From: Thomas Callaway
Sent: 10 September 2014 16:44
To: Planning.Responses
Subject: RE: Planning Consultation on BE/95/14/DOC

Registered: 14-AUG-14
Site Address: Oldlands Farm Steyning Way Bognor Regis PO22 9NN

Application for approval of details reserved by conditions 3 (surface water drainage) and 6 (sustainable drainage principles) following a grant of planning permission BE/61/13/.

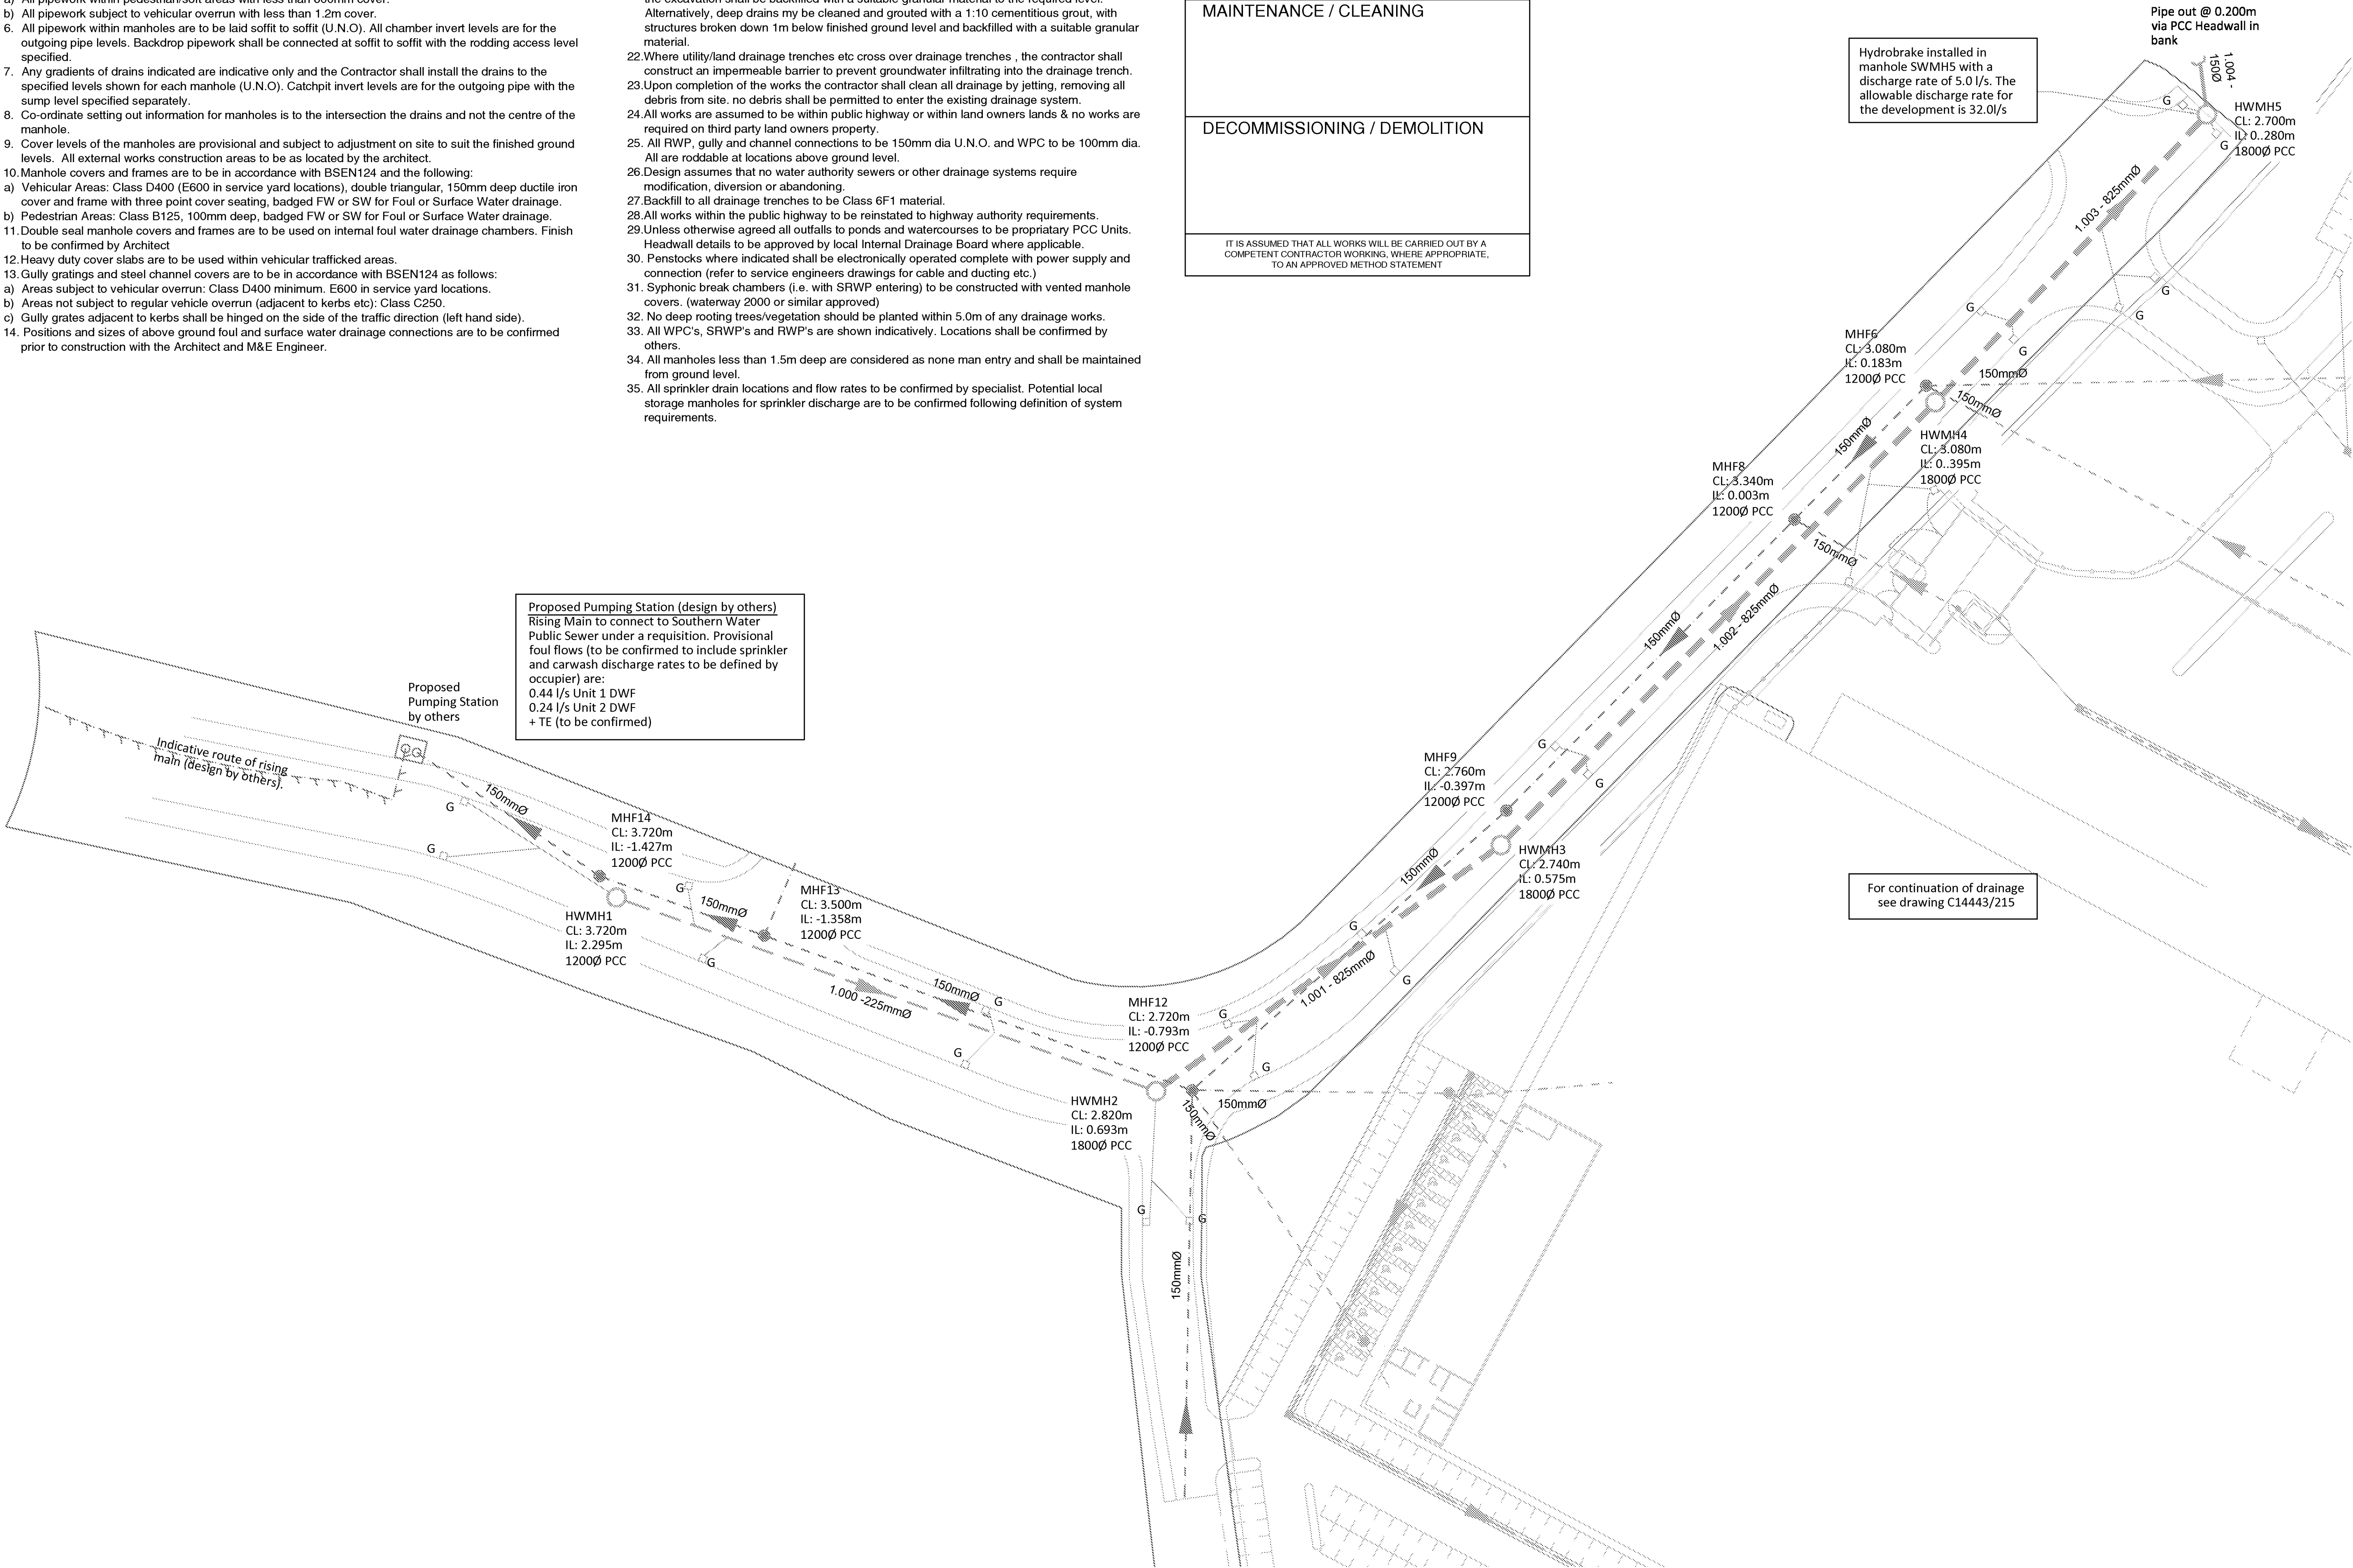
It was originally requested that infiltration was investigated. This would be a suitable method of surface water drainage if it has been confirmed that ground conditions allow for it and that there is no contamination on site. We have no results of any groundwater monitoring or percolation testing, or confirmation that the site is not contaminated.

The highway is to be adopted, West Sussex County Council Highways should be consulted to ensure that drainage is to an adoptable standard.
